May 15, 2024

**Re: Oxbow Center Subdivision (Private Utilities and Roadway) at 3901 Coors Blvd. NW
Erosion and Sediment Control Plan
Engineer's Stamp Date 5/8/24 (G11E067)**

Based on the information in your submittal, received on 5/8/24, the above-referenced ESC Plan cannot be approved for Grading and Paving Permits until the following comments are addressed.

ESC-1

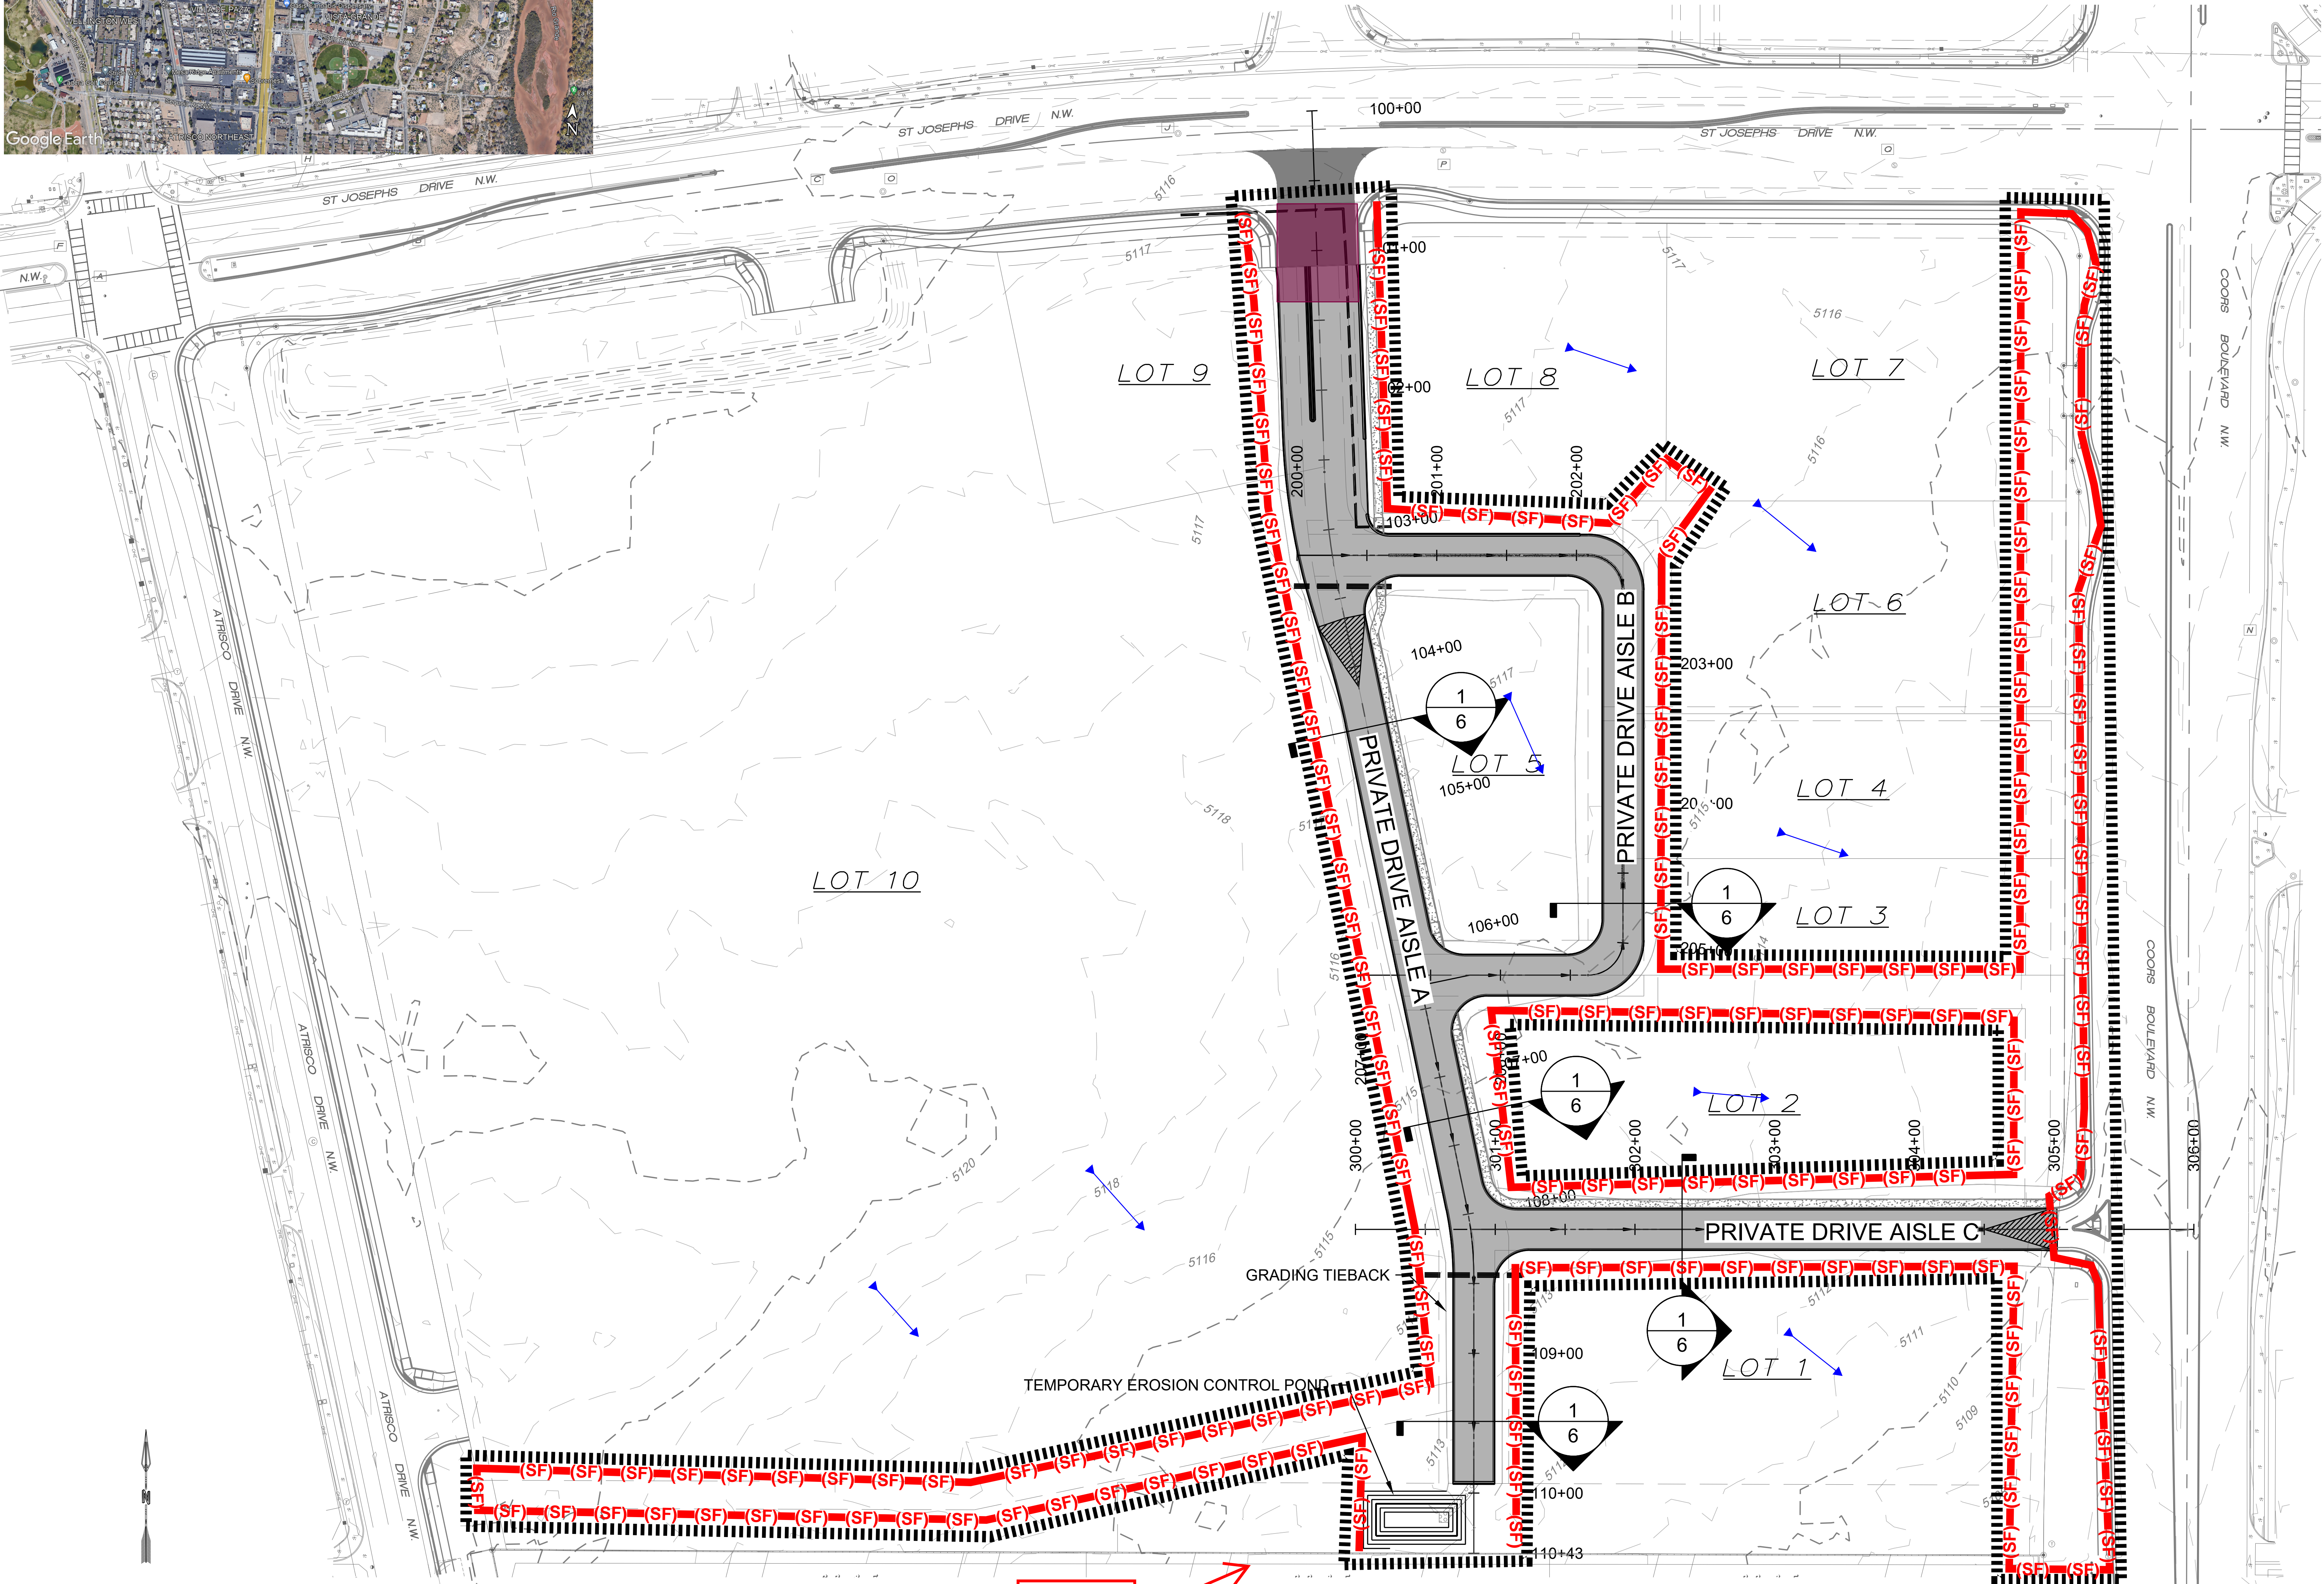
1. Sheet ESC-1 says it includes 6.53 acres of land-disturbing activities on a 27.97-acre site. Tax records show Tract X-2-A had 26.47 acres before the plat of "Lots 1 thru 10 of the University of Albuquerque Urban Center" dedicated 0.53 acres of additional right-of-way to the public. However, the total area of this "Common Plan of Development or Sale" is about 29.2 acres, including the 3.3-acre frontage improvements. So it doesn't seem that all of the property owner's land-disturbing activities are included in the 6.53 acre on sheet ESC-1. Correct the area of land-disturbing activities on sheet ESC-1 and on the NOI to include all phases.

- vi. The completion of Construction and Stabilization before removal of BMPs and before connection to any downstream stormdrain.
3. The scale of the ESC Plan is missing. Include a graphic scale and north arrow on each sheet. A scale of 1"=50' is suggested. The scale must be adequate to show the improvements and BMPs clearly. More than one sheet may be needed. All phases must be shown clearly.

4. Proposed contours are missing. You must show drainage patterns after grading activities per CGP 7.2.4.f and slopes per CGP 7.2.4.b.ii. Identify locations of concentrated flow paths that enter and exit the disturbed areas. Proposed grades must be shown on the ESC Plan to indicate the drainage patterns after grading activities.

5. Clearly identify the areas where the existing vegetation is to be preserved and specify BMPs to protect them. All of lot 5 is shown within the limits of land disturbance. Identify the activities that will take place on lot 5.

6. Show locations where sediment, soil, or other construction materials will be stockpiled per CGP 7.2.4.b.iii and onsite and offsite construction support activity locations per CGP 7.2.4.b.

7. The locations of existing and proposed structures and other impervious surfaces are unclear, particularly along the frontage of the adjacent public streets. Show all existing and proposed structures and other impervious surfaces upon completion of this construction per CGP 7.2.4.b. The lines and line types along the frontage streets are confusing and are not identified in any legend. You may want to show the improvements for different phases on separate sheets, particularly if the phases won't be constructed simultaneously. You must clearly identify the locations of the existing and proposed impervious surfaces.

9. Show locations where stormwater will be discharged per CGP 7.2.4.g. Show all existing and proposed storm drains and inlets.
10. The receiving waters are the Rio Grande. Correct the NOI and ESC Plan, where they say the receiving waters are an on-site retention pond.
